Ribble Valley Borough Council
By email

Your ref: 3/2023/0634
Our ref: DC/23/3022 v2
Date: 02-OCT-23

Location: Primrose House Primrose Road Clitheroe BB7 1DR
Proposal: proposed single-storey self-build dwelling with associated car port

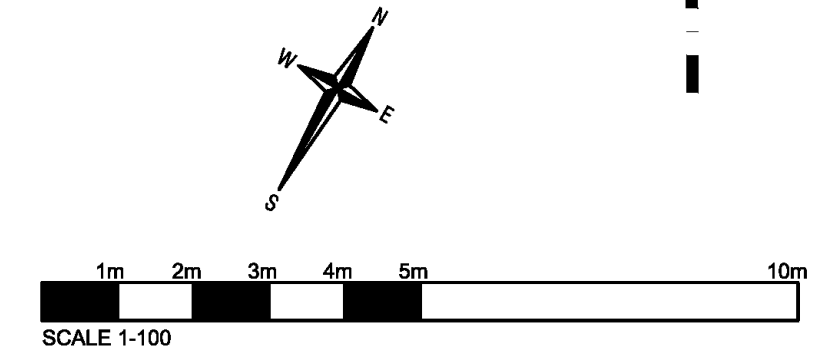
Following our review of the submitted drainage documents; Drainage Strategy Ref: 1165-2301-CIV-DS10, Dated July 2023, the plans are not acceptable to United Utilities. Can the applicant please show finished floor levels in metres AOD on their plan.
